FIVE ESTUARIES OFFSHORE WIND FARM

**Appendix B6 Natural England's Marine Processes advice on the Applicant's Deadline
4 Documents**

Planning Inspectorate Reference EN010115

11 February 2025

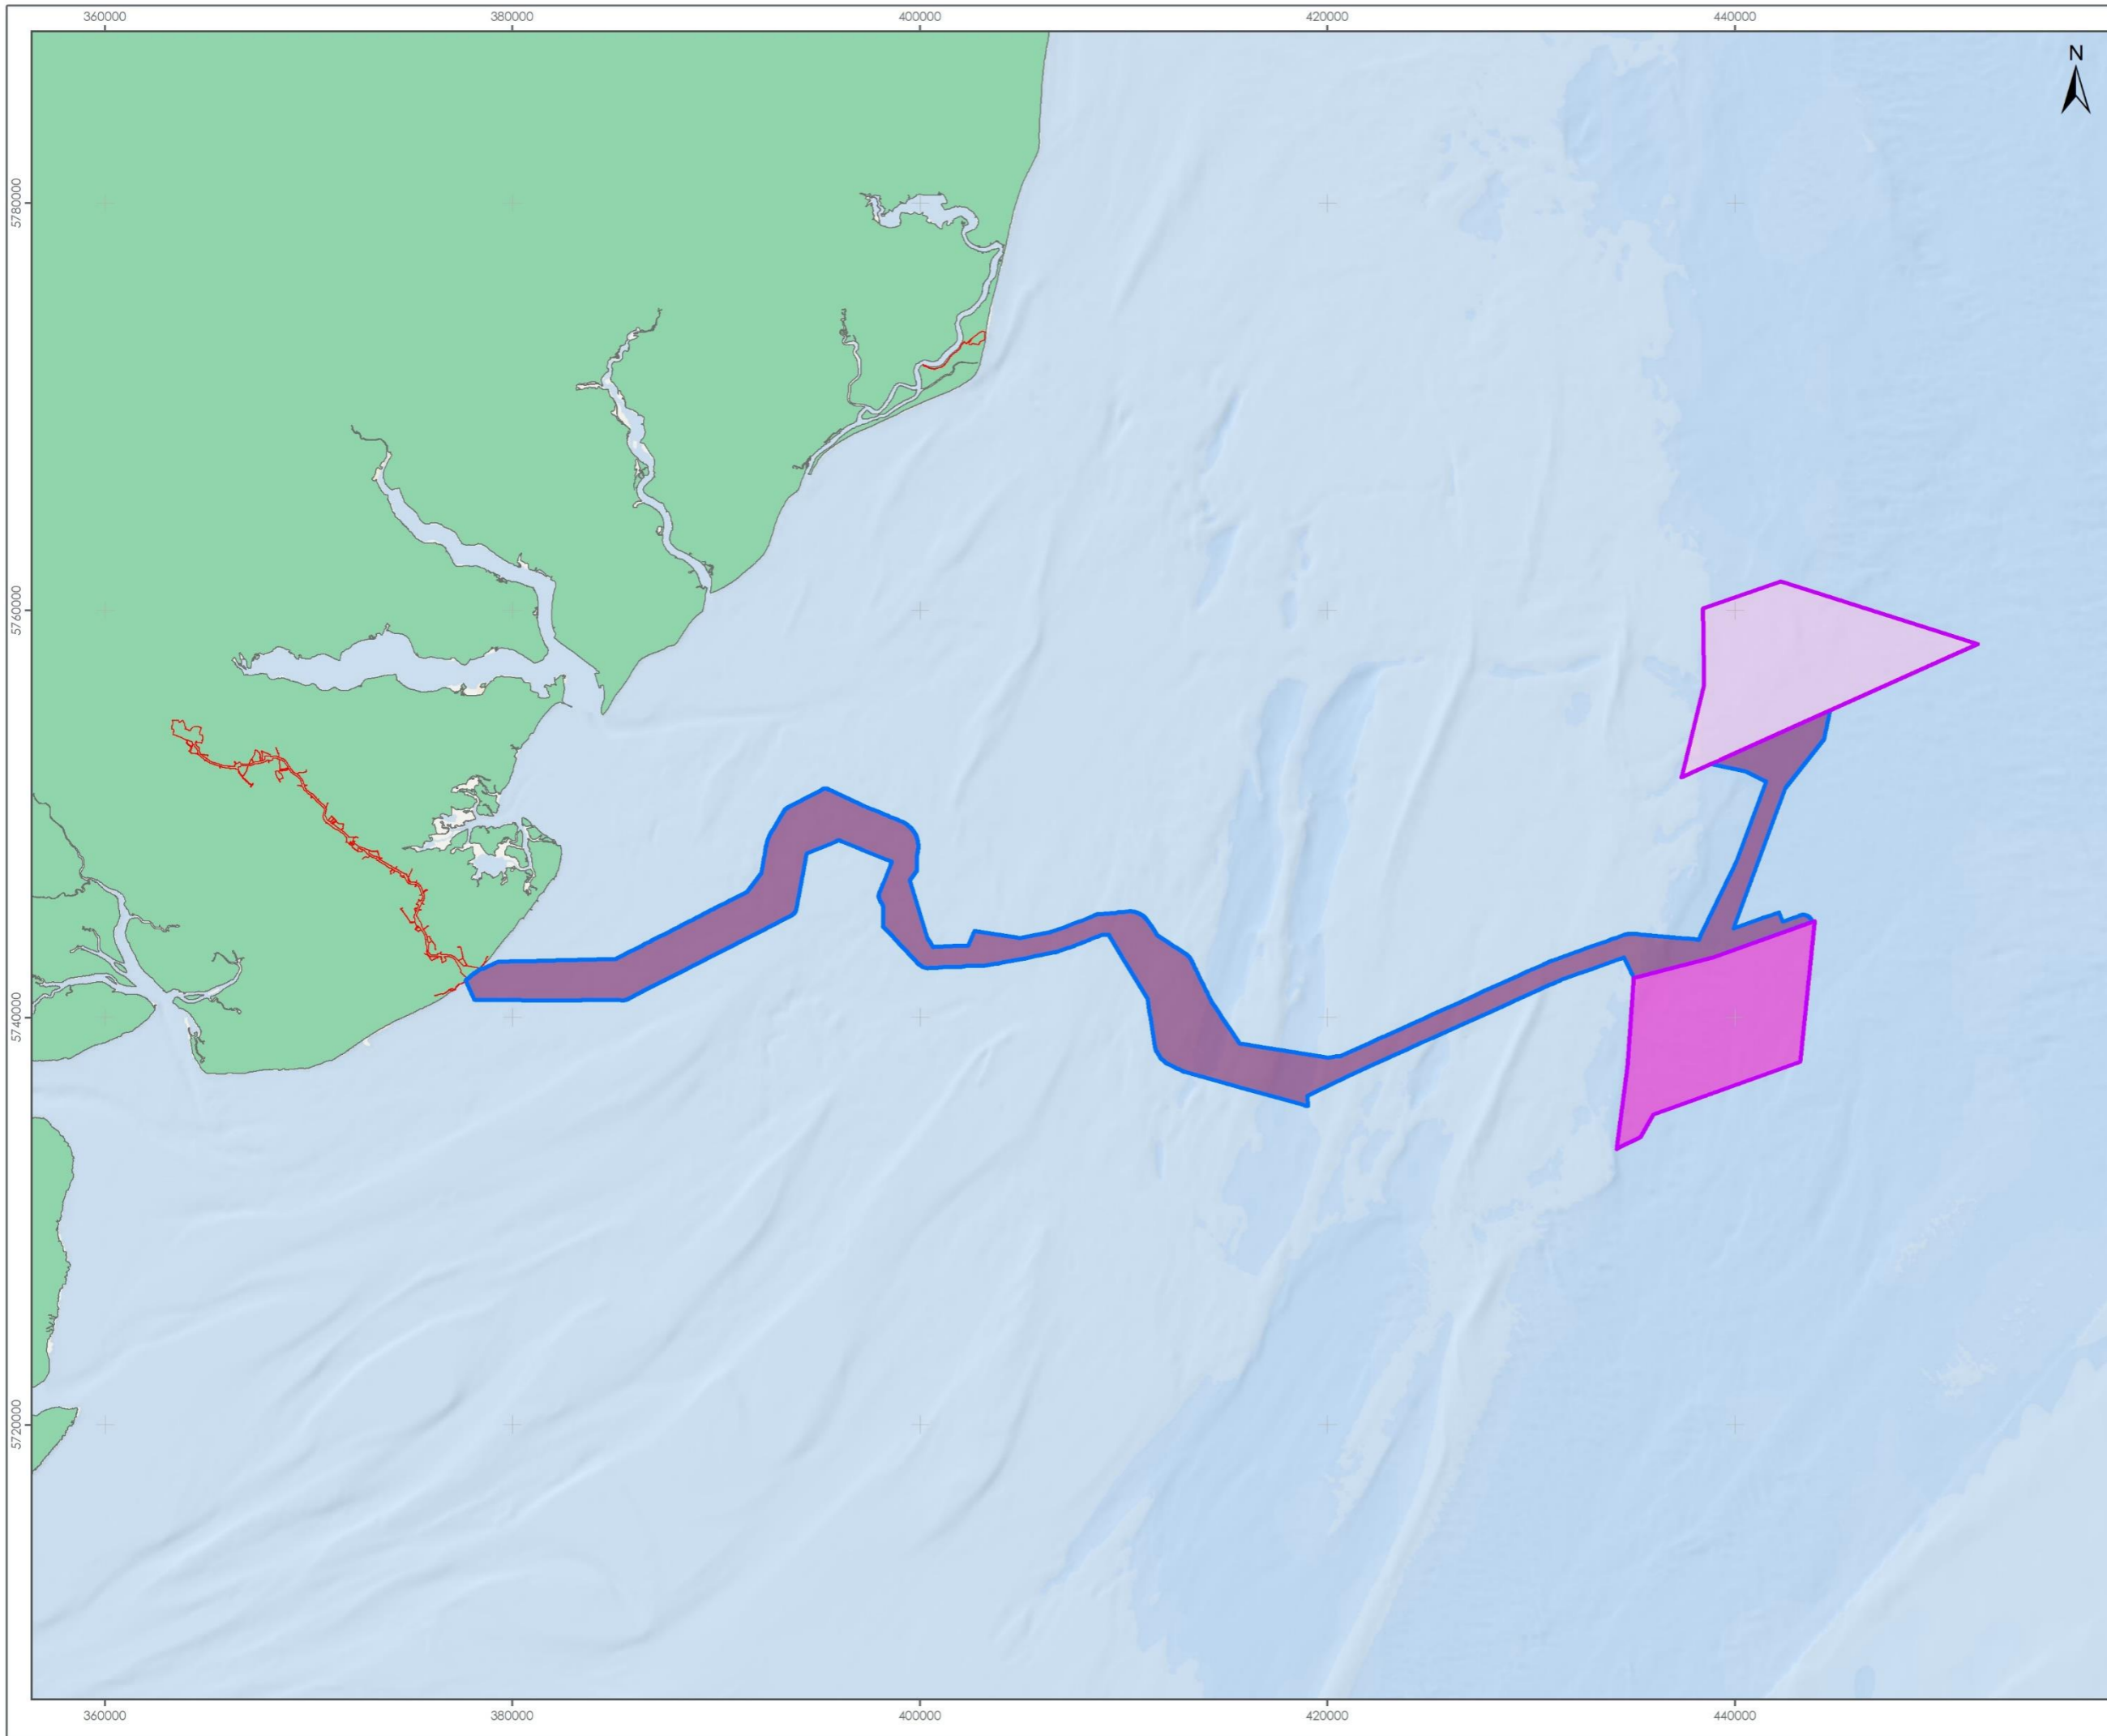
13	1.2.5	Natural England suggests that there are in fact 3 disposal areas namely, Array (North and South), ECC outside SAC and ECC within SAC	Natural England suggests this, and other documents are updated to ensure that there are no ambiguities of what is proposed where.
14	2.1.2	Natural England advises that clarification is required within updated text to confirm that only a fall/down pipe will be used in MLS SAC	Natural England advises that tracked change text includes '...but only a fall/down pipe will be used in MLS SAC'

3.2 SEDIMENT MOBILITY

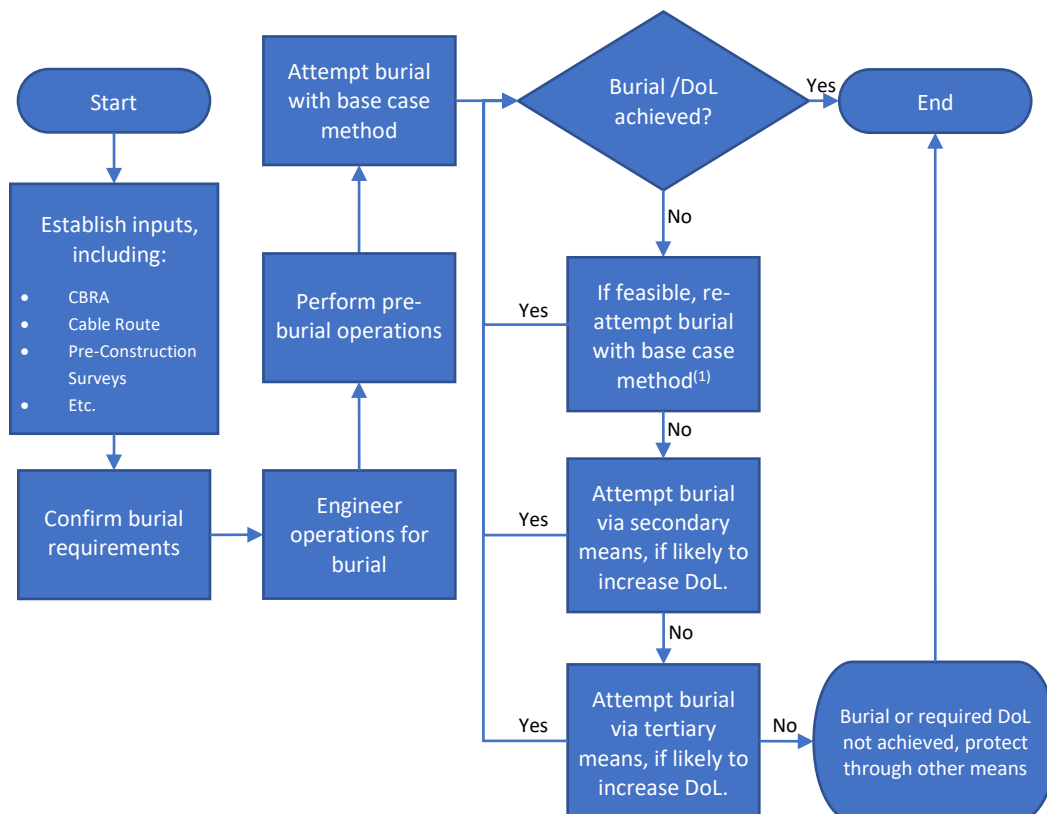
6	3.2.1	It is stated that material removed from MLS SAC will be placed within the offshore ECC via a discharge pipe/downpipe within MLS SAC to ensure that sediment remains within the same sedimentary cell and no sediment is removed from the local sediment transport system.	Natural England advises that in order to maximise the potential for seabed morphological recovery and limit the effects on the wider sediment transport processes in the SAC, that commitments are also made to deposited dredged material updrift of levelling/seabed preparation and cable trenching operations and within same sediment type, to encourage natural backfill and reworking of material (except where an upstream deposition may have an adverse impact on another feature).
Document reviewed: [REP4-035] 10.20.1 Technical Note – Methodology for Determining MDS (Offshore) – Revision B (Tracked)			
NE Ref	Section	Key Concern and/or Update	Natural England's Advice to Resolve Issue
